## **PLANNING REFERENCE 21/02913/FUL**

### **LAND AT DUCK END FARM, PARK LANE, DRY DRAYTON, CB23 8DB**

Please find attached to this letter a Non-material amendment (S96A) application which follows the grant of planning permission 21/02913/FUL in December 2021.

drawing title  
**Elevations - New House - Proposed**

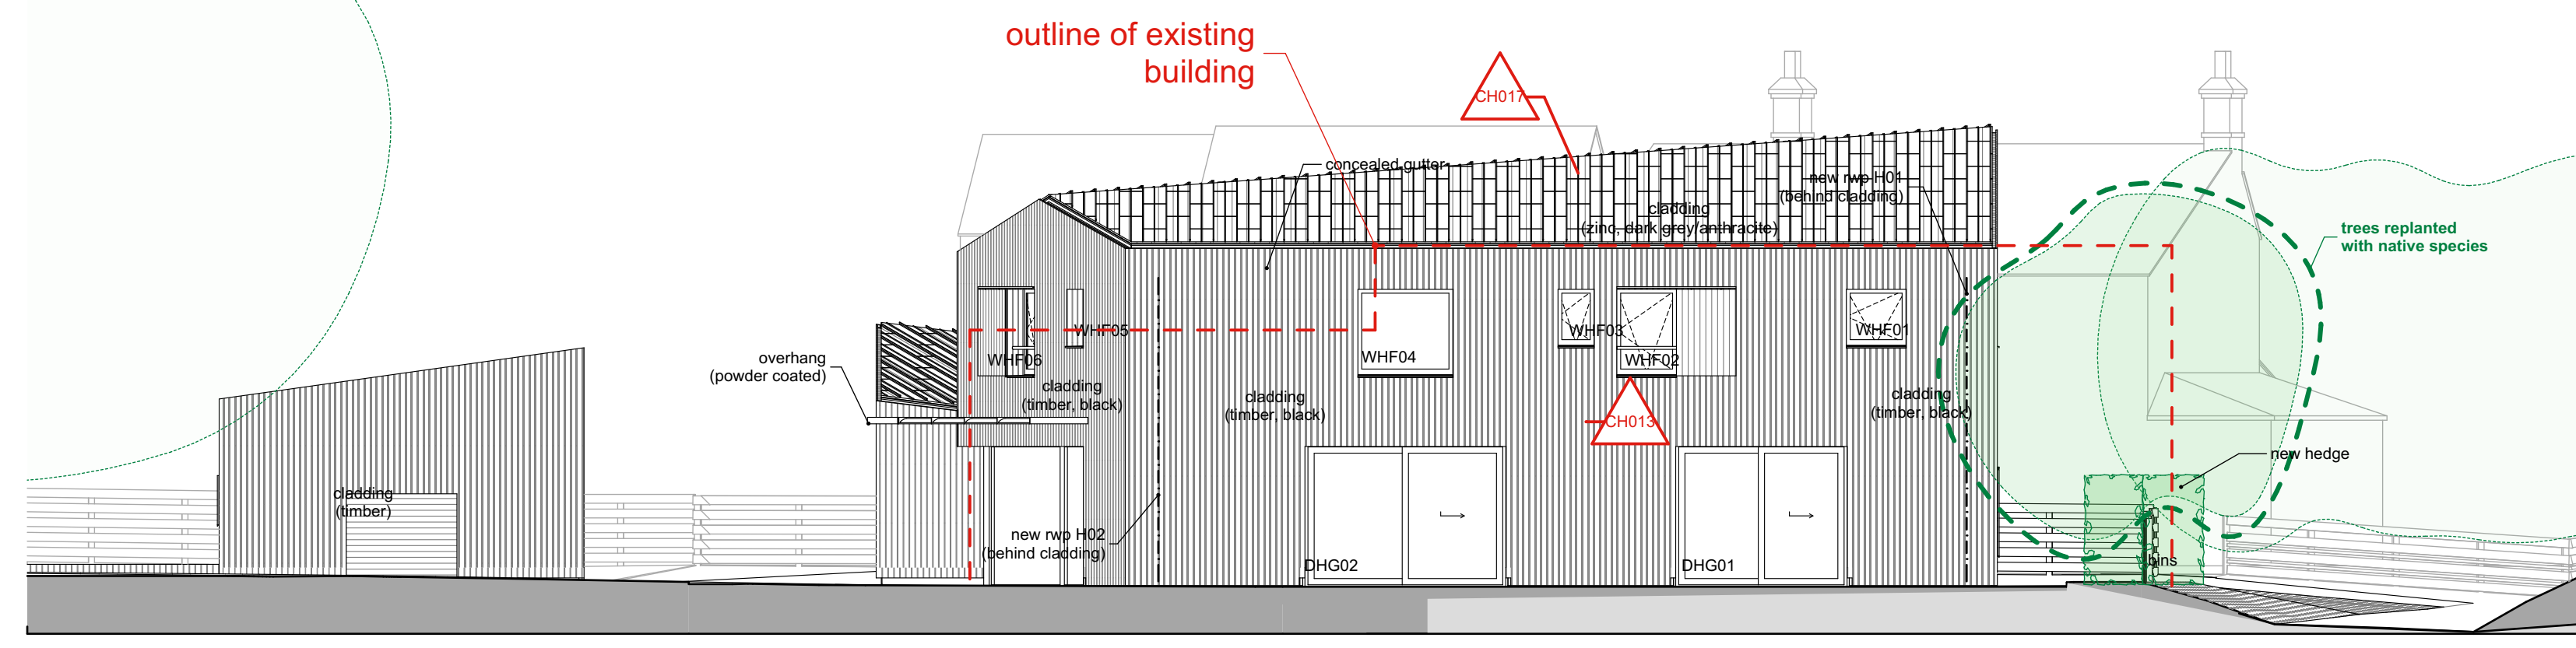
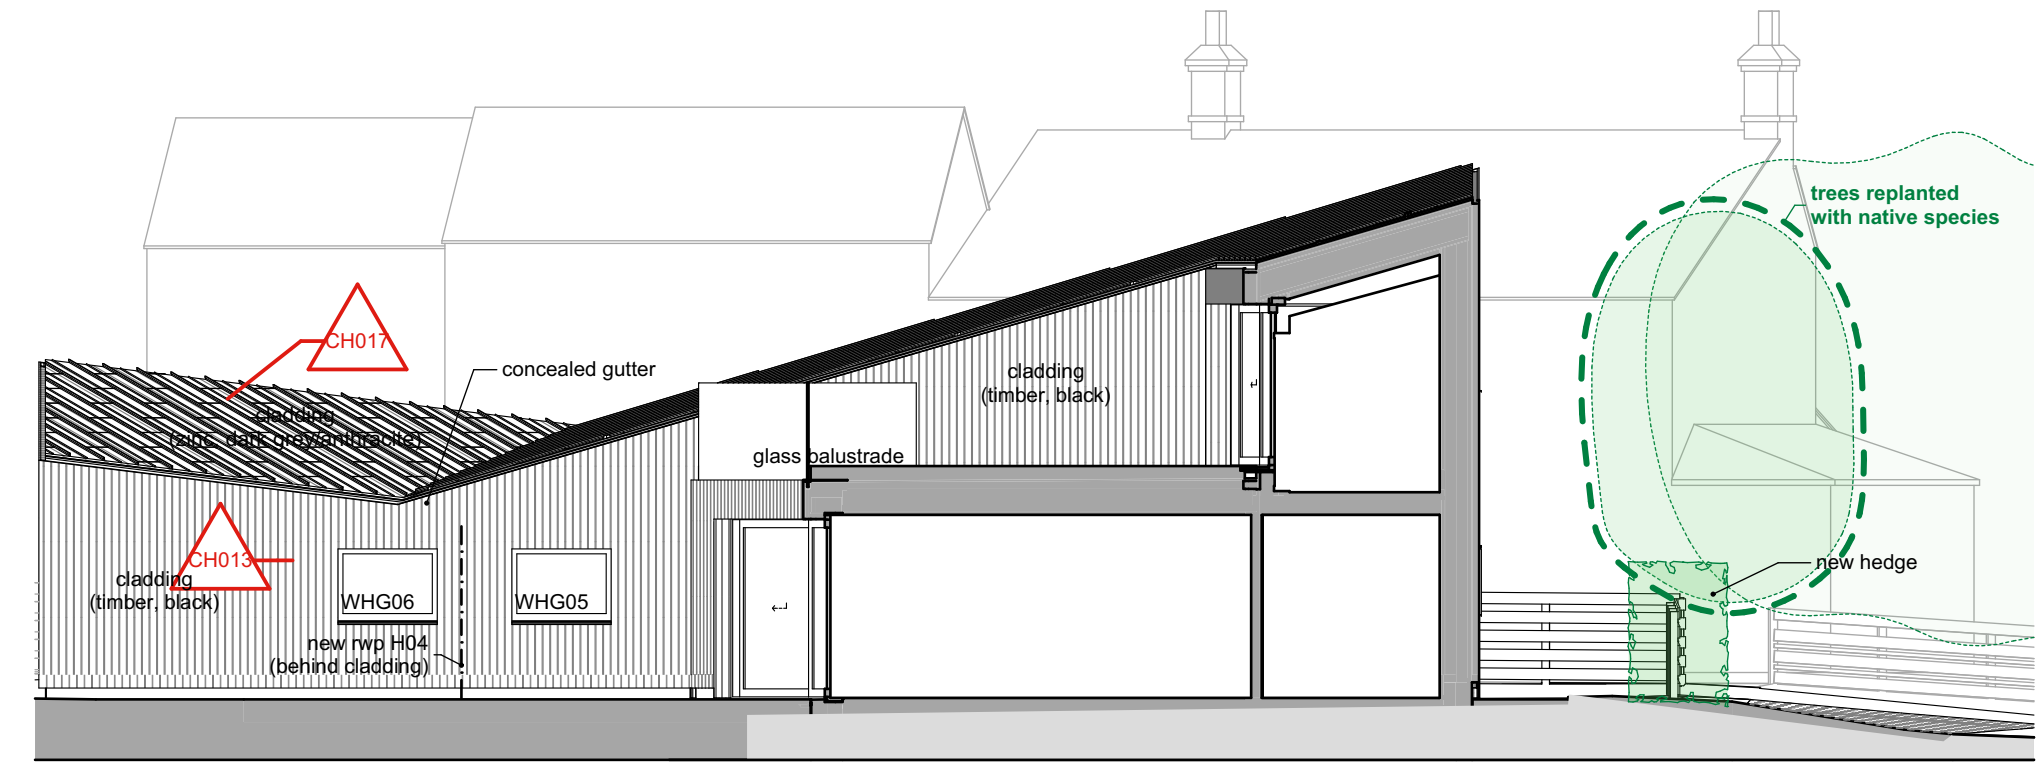
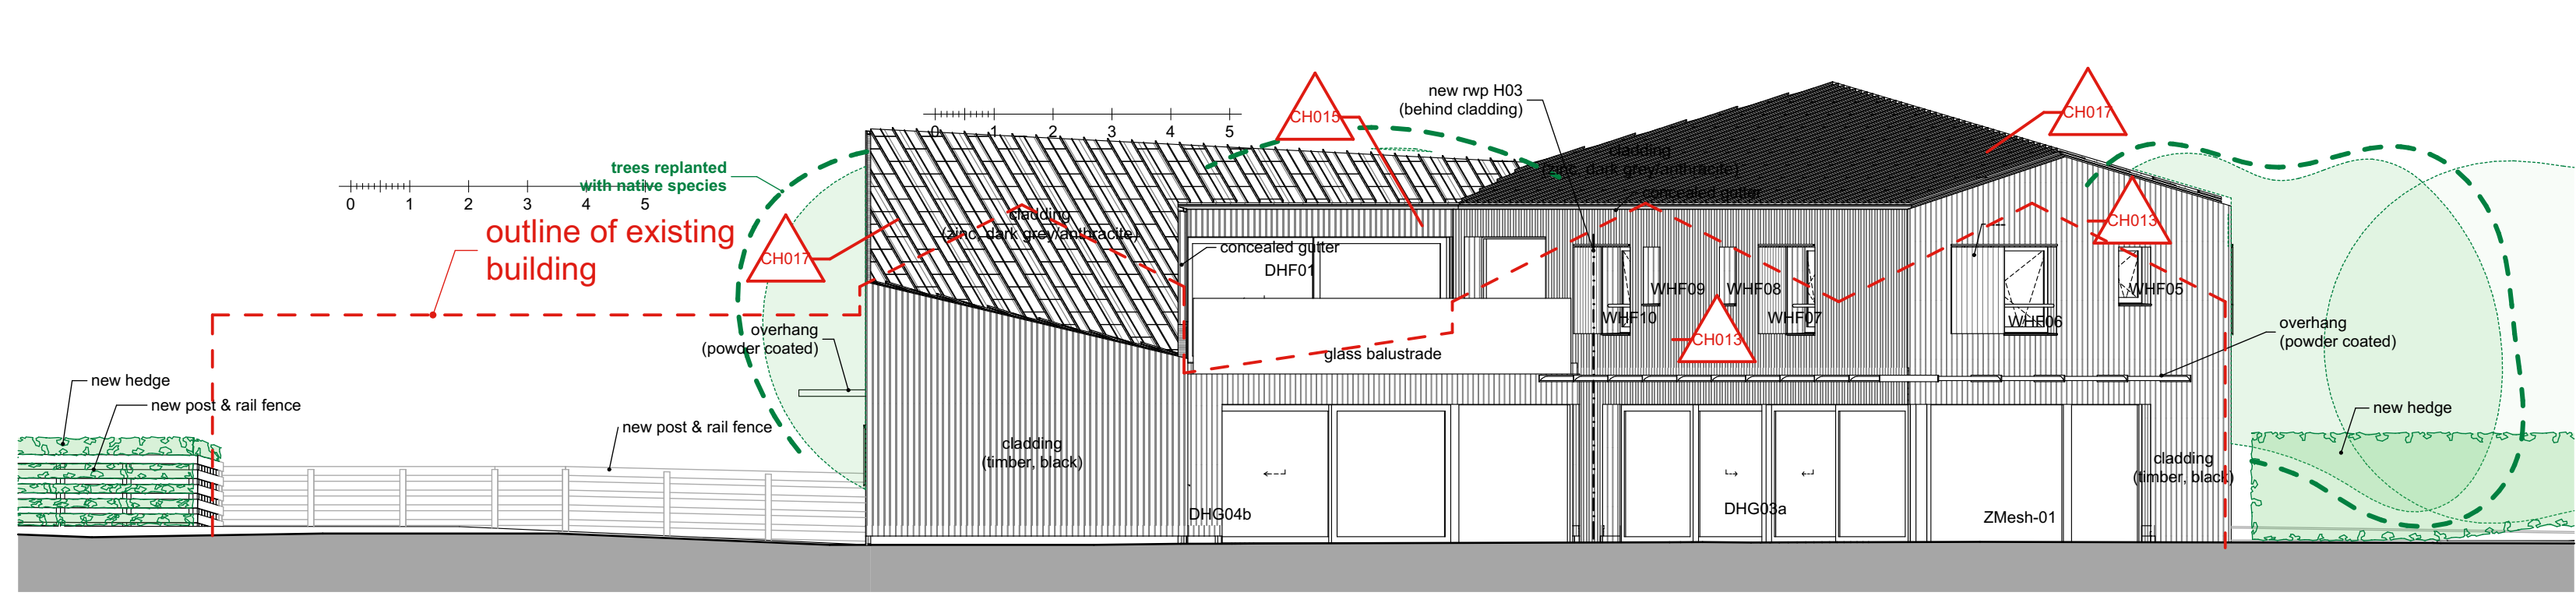
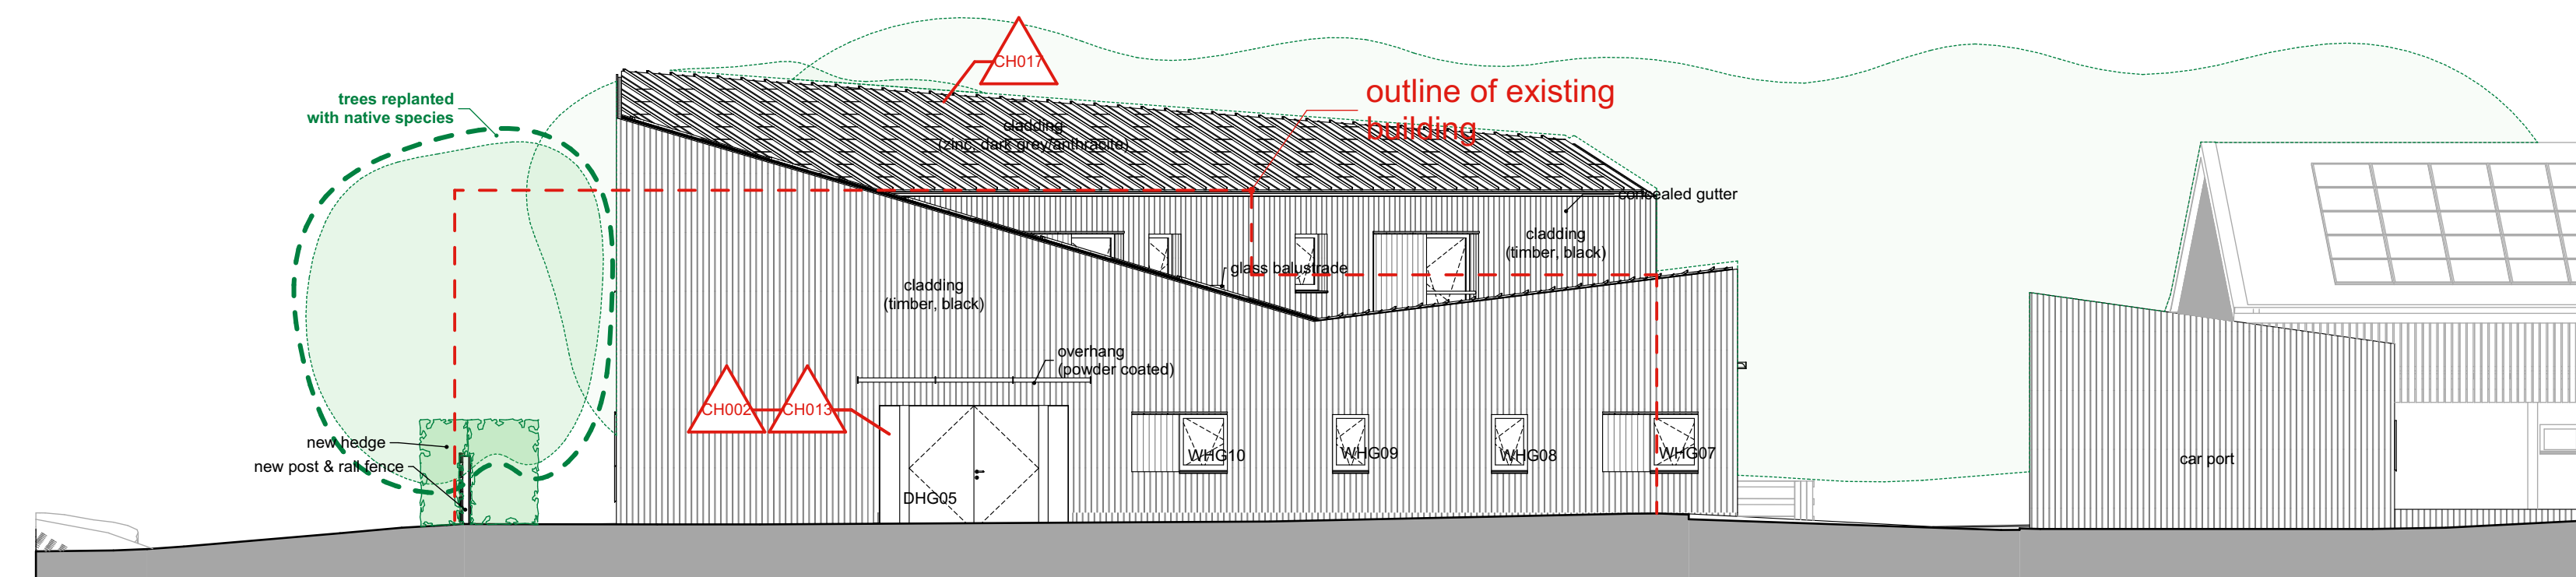
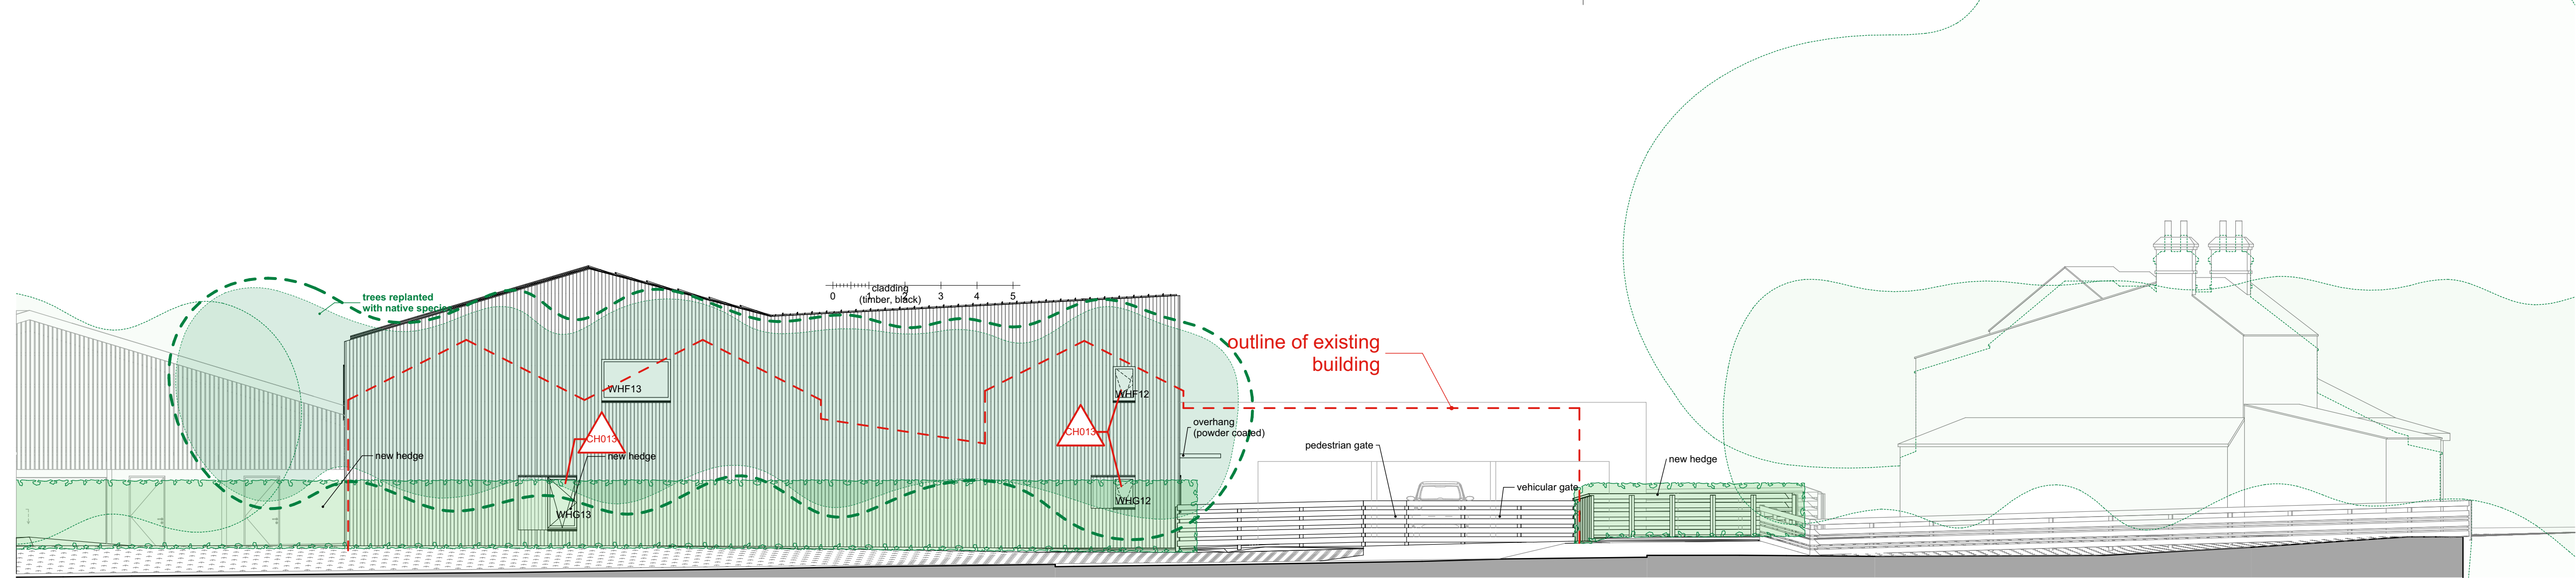
- Change in finish of the roof from timber cladding to a standing seam zinc, coloured in dark grey. This will match the proposed cladding.
- Addition of a door to the barn for plant room access.
- Window size/ lateral position adjustments to fit selected cladding system.
